**From:** Heather Forgey <forgeyh@ci.ellensburg.wa.us>  
**Sent:** Thursday, May 03, 2018 3:38 PM  
**To:** Lindsey Ozbolt; Mark Cook  
**Subject:** RE: Blackhorse Final Development Plan - Minor Amendment

**From:** Lindsey Ozbolt <[lindsey.ozbolt@co.kittitas.wa.us](mailto:lindsey.ozbolt@co.kittitas.wa.us)>  
**Sent:** Thursday, April 19, 2018 4:58 PM  
**To:** Mark Cook <[mark.cook@co.kittitas.wa.us](mailto:mark.cook@co.kittitas.wa.us)>; Heather Forgey <[forgeyh@ci.ellensburg.wa.us](mailto:forgeyh@ci.ellensburg.wa.us)>  
**Subject:** Blackhorse Final Development Plan - Minor Amendment

Kittitas County Community Development Services received a request for a minor amendment of the Blackhorse Final Development Plan limited to the phasing and timing of the development. Pursuant to Kittitas County Code 17.36.080.1, minor alterations may be approved by the Director. CDS has determined this request does qualify as a minor amendment.

KITTAS COUNTY UTILITY PHASING PLAN WASHINGTON

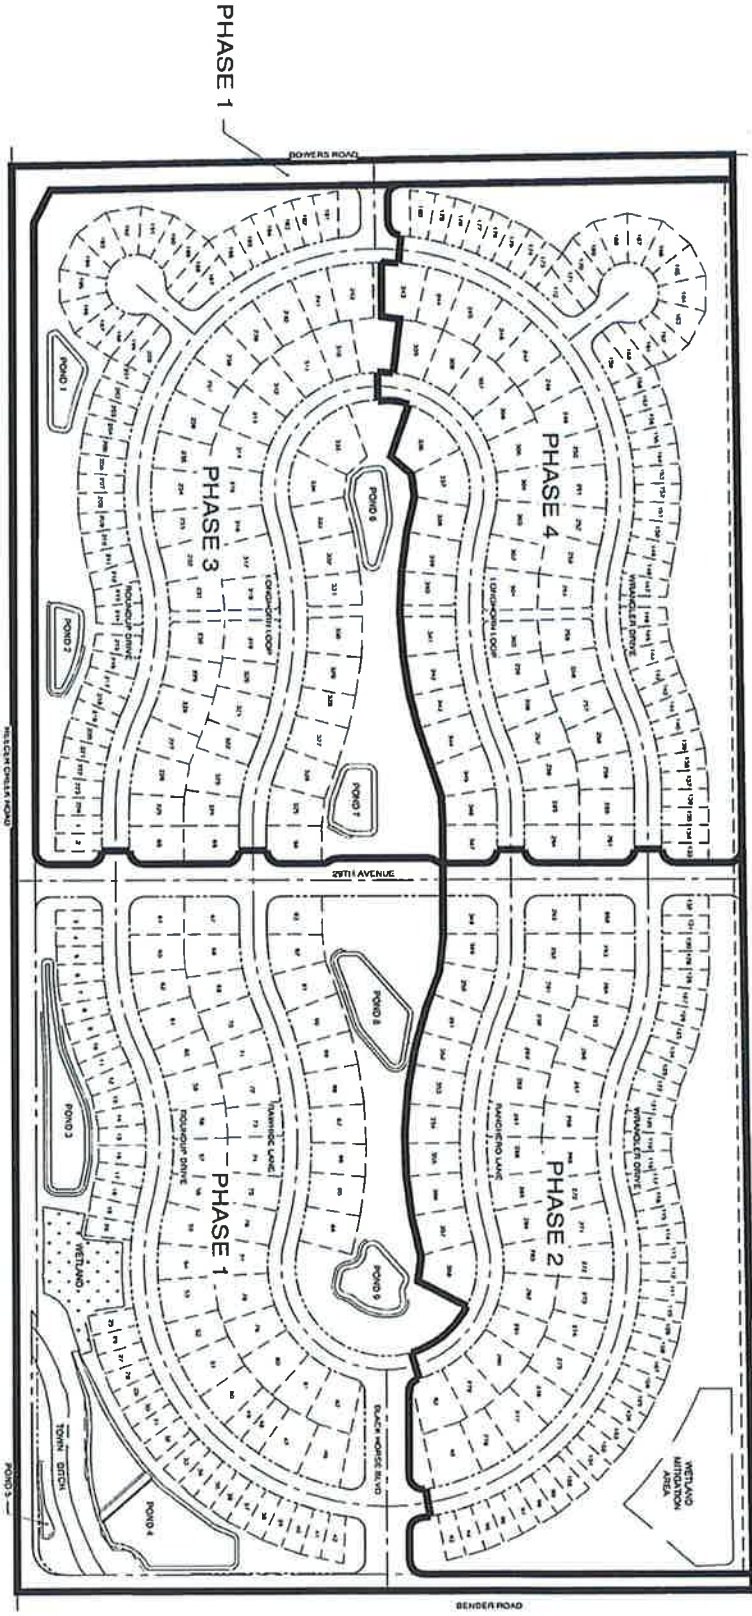
There are no major concerns with these phasing changes with regards to the natural gas infrastructure, however we would highly appreciate extending the gas main at the NE part of the project along the Bowers Road frontage which was originally part of Phase 1 but now appears to be pushed to Division 2.
